# Engineers Comments Regarding Surface Water Drainage

<b>Application Reference:</b>	BE/44/25/PL	<b>Reviewer Reference:</b>	ADC/PC
<b>Planning Officer:</b>	Hannah Kersley	<b>Date of Review:</b>	31/07/2025
<b>Site Name:</b>	Land adjacent to 21 Greencourt Drive Bersted PO21 5EU		
<b>Application Description:</b>	2 No 2 bedroom detached bungalows with associated car parking and bin and bike stores (resubmission following BE/70/24/PL. This application is in CIL Zone 4 and is CIL Liable as new dwellings.		
<b>Assessment Number:</b>	1 of 1

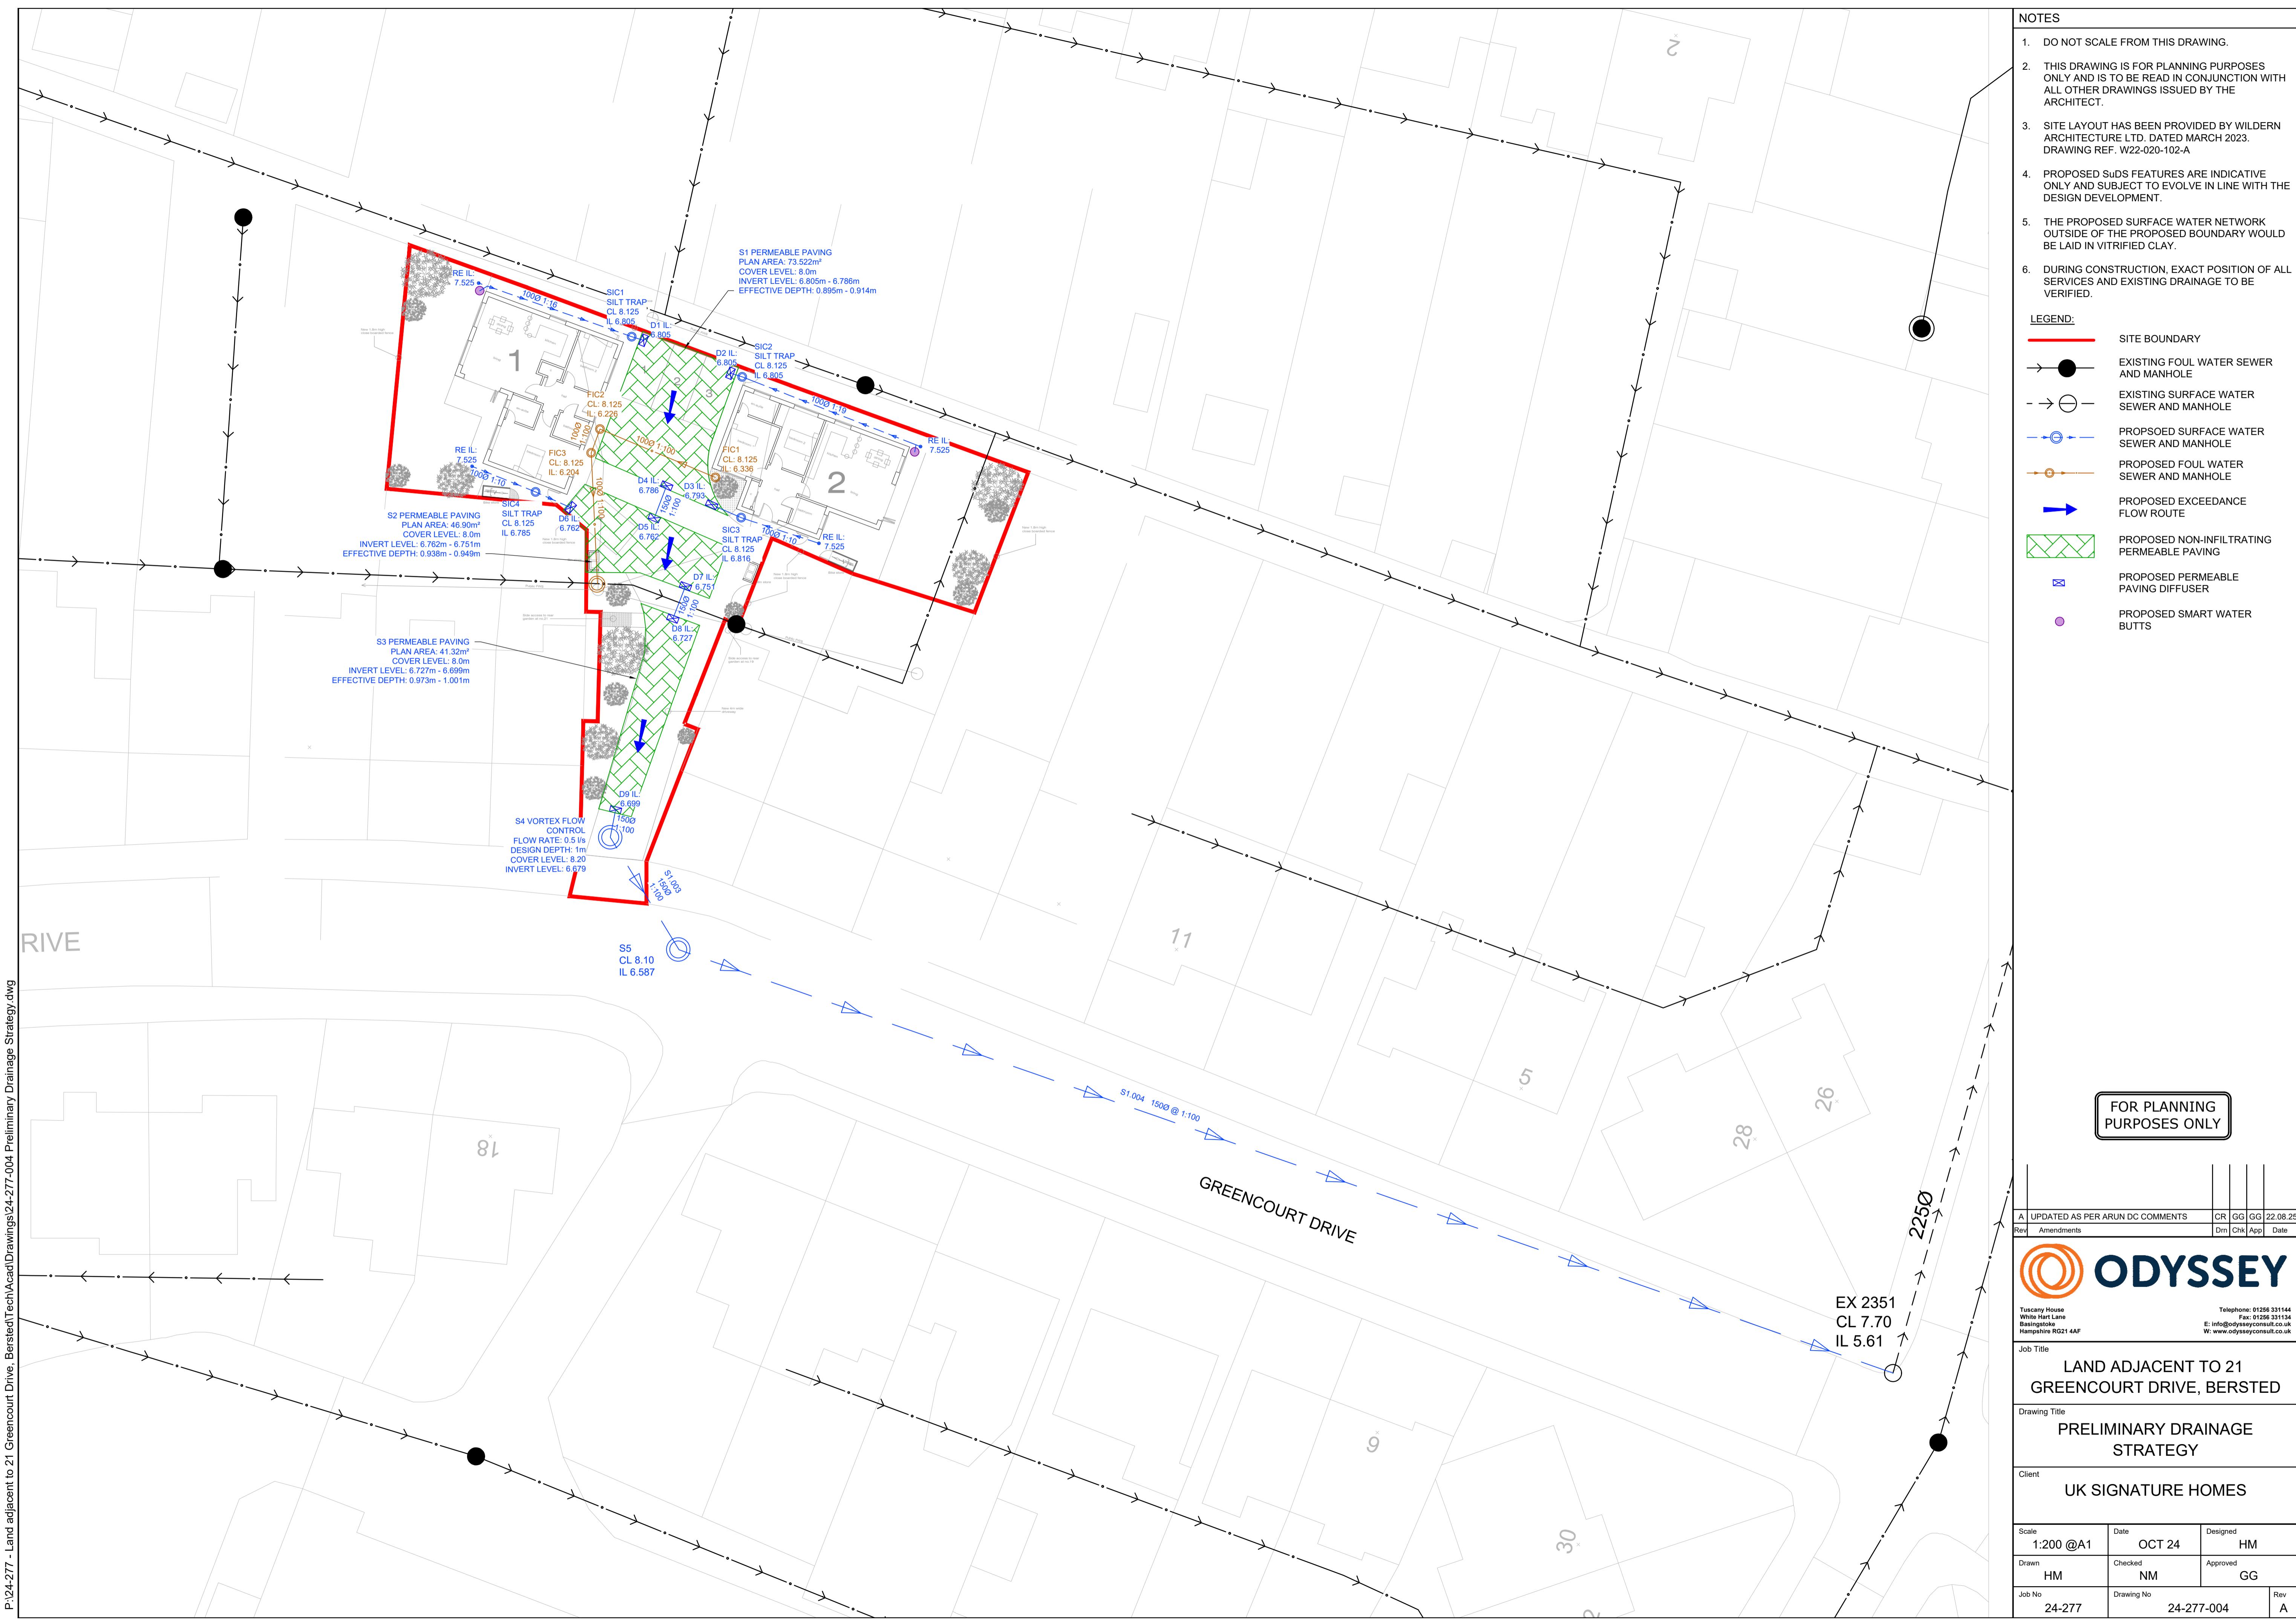
3. The applicant should note that the existing manhole being connected to at the junction of Greencourt Drive and South Way may be at a slightly different location to that shown on the drainage layout plan ie. more into the footpath. Also, it would be advisable to ensure that no third party utility mains/services, including the existing highway drainage in Greencourt Drive, conflict with the routing and levels of the proposed pipework, etc. This matters may result in having to reconfigure the proposed offsite pipework to enable a suitable connection.

4. It is noted that there will be a considerable length of 'offsite' pipework and associated manhole/s. Confirmation is required as to whether these assets are to be adopted by a Water Company. Evidence of agreement in principle from the Water Company will be required. It is unlikely, that West Sussex County Council (WSCC), as Highway Authority will permit an unadopted arrangement in the public highway and therefore it is important to establish its future status. If adoption is not sought, then confirmation will be required from WSCC that the principle of the arrangement is acceptable to them.

6. Provide an impermeable area plan to support the hydraulic calculations.
7. The drainage layout must include the pipework/manhole arrangements around the two dwellings and show the connectivity to the permeable paving. Manhole cover levels, invert levels, pipe diameters and gradients to be included. All diffuser units (including those linking the permeable pavements) to have inverts specified. Indicate diameters/gradients of all link pipes. Silt traps to be incorporated prior to any discharge into permeable paving.

8. Provide a location plan for the water table monitoring boreholes, to confirm that they are located on site.
9. Interception drainage needs to be considered. This could take the form of smart water butts and/or other methods of rainwater harvesting. Indicate on drainage layout.
